D49 Elementary, PPR-17-019

Please accept the following comments from El Paso County Public Health regarding the project referenced above:

SHEET: **EX1**

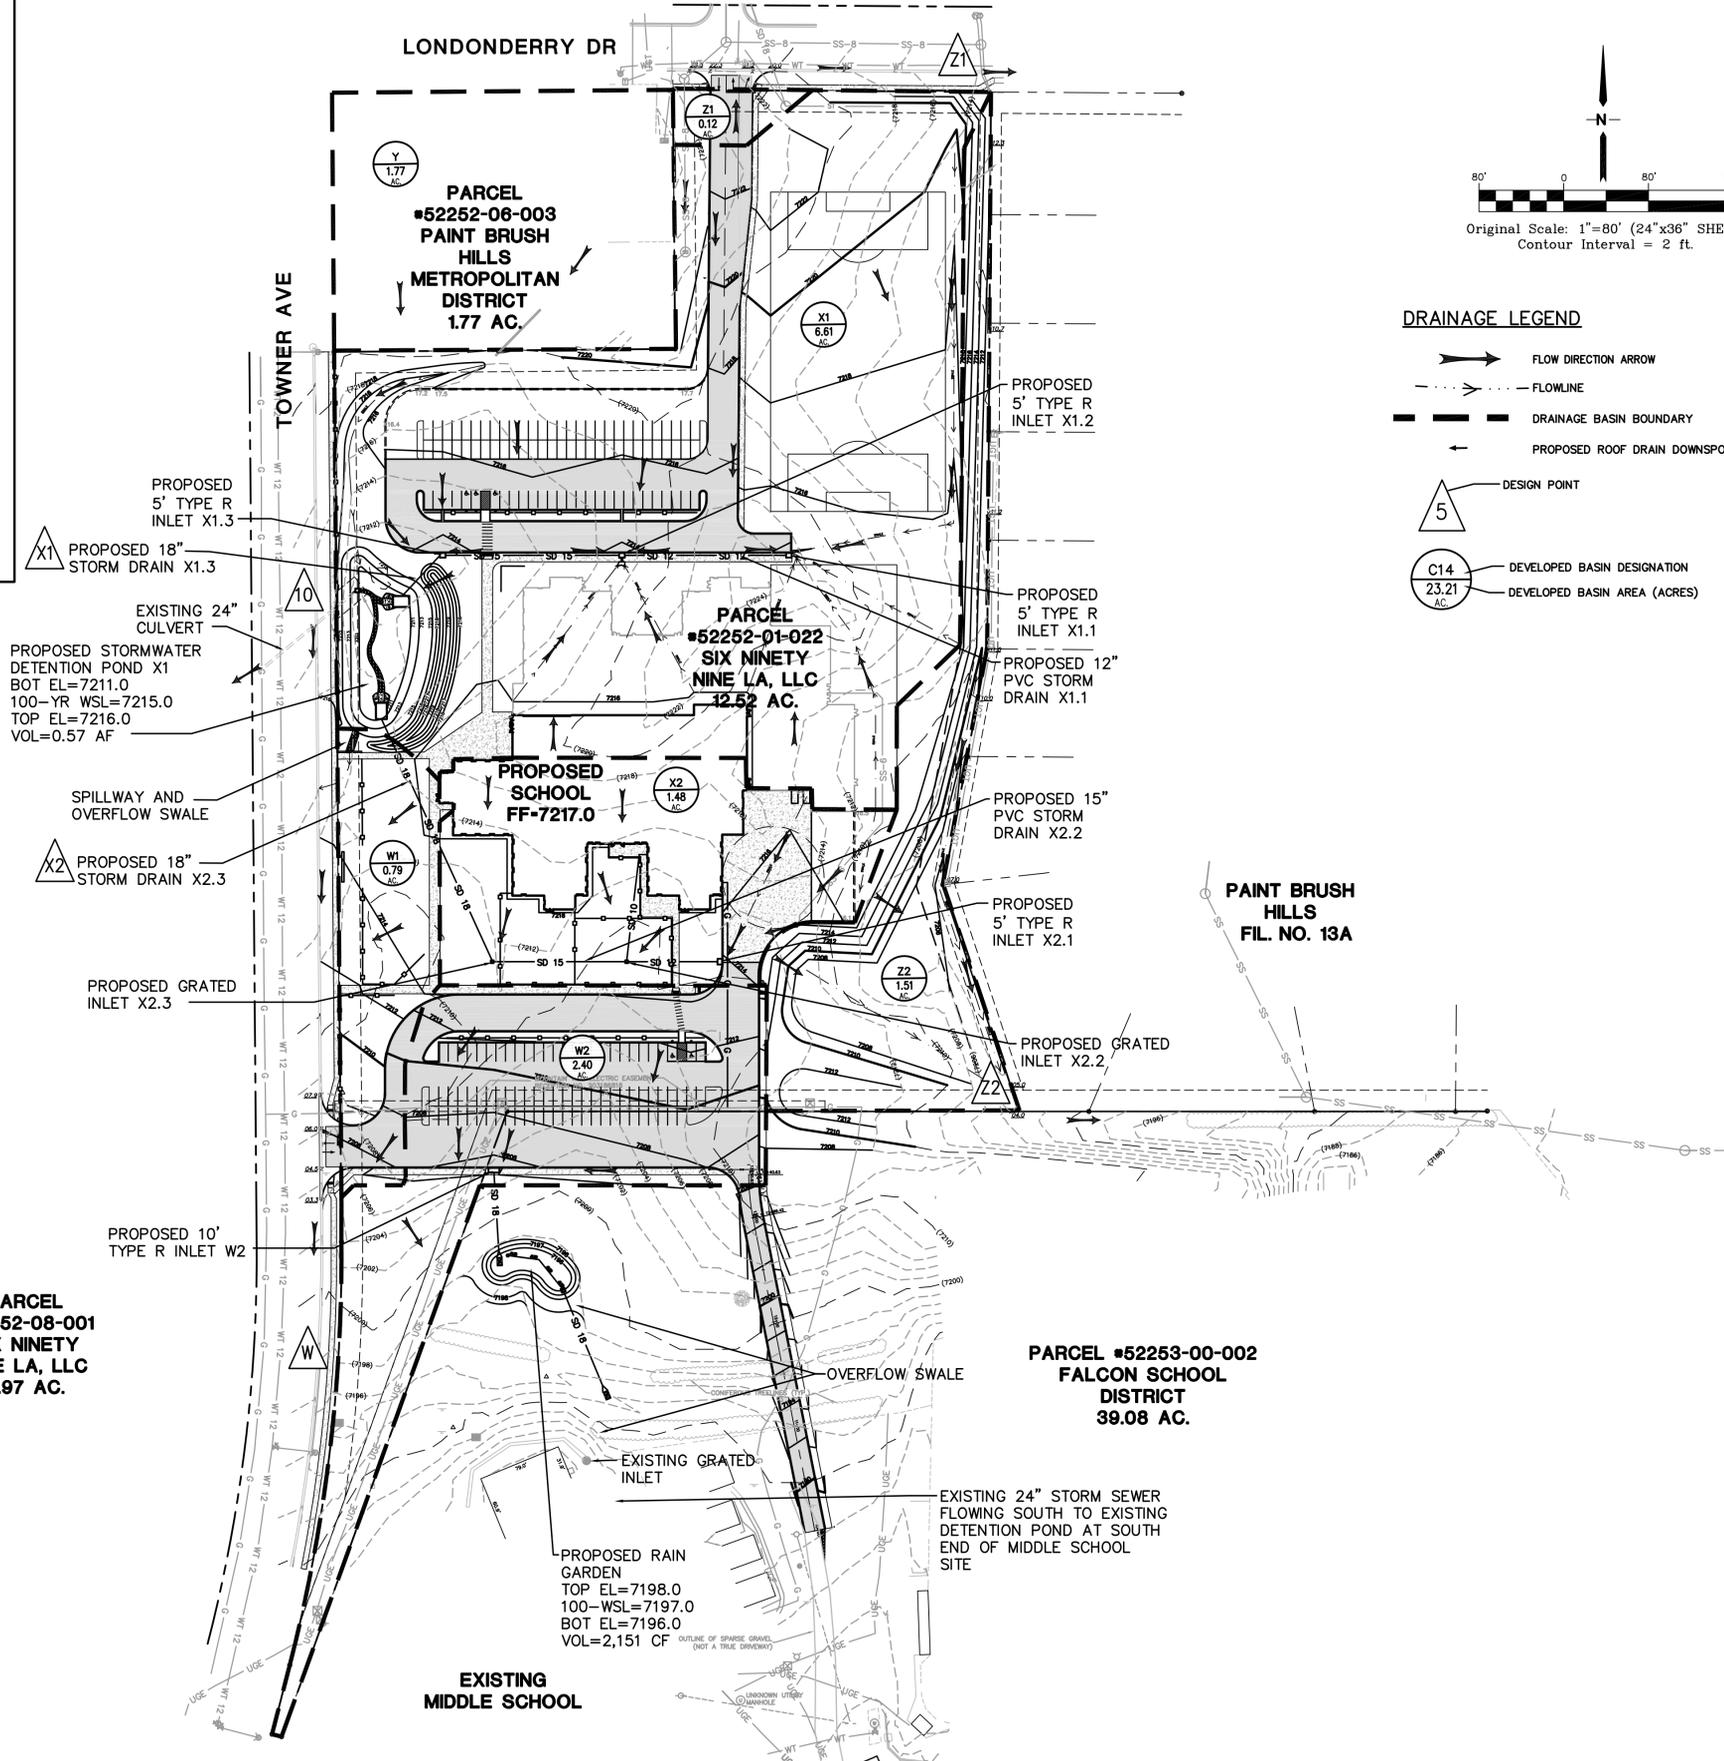
- **The storm water detention pond located on the west side of the development must be designed and maintained to minimize the stagnation of drainage water; thereby, reducing potential mosquito habitat, and minimizing the risks of mosquito borne diseases. Maintenance responsibilities of the storm water detention pond must be in writing and agreed upon by Falcon School District 49.**
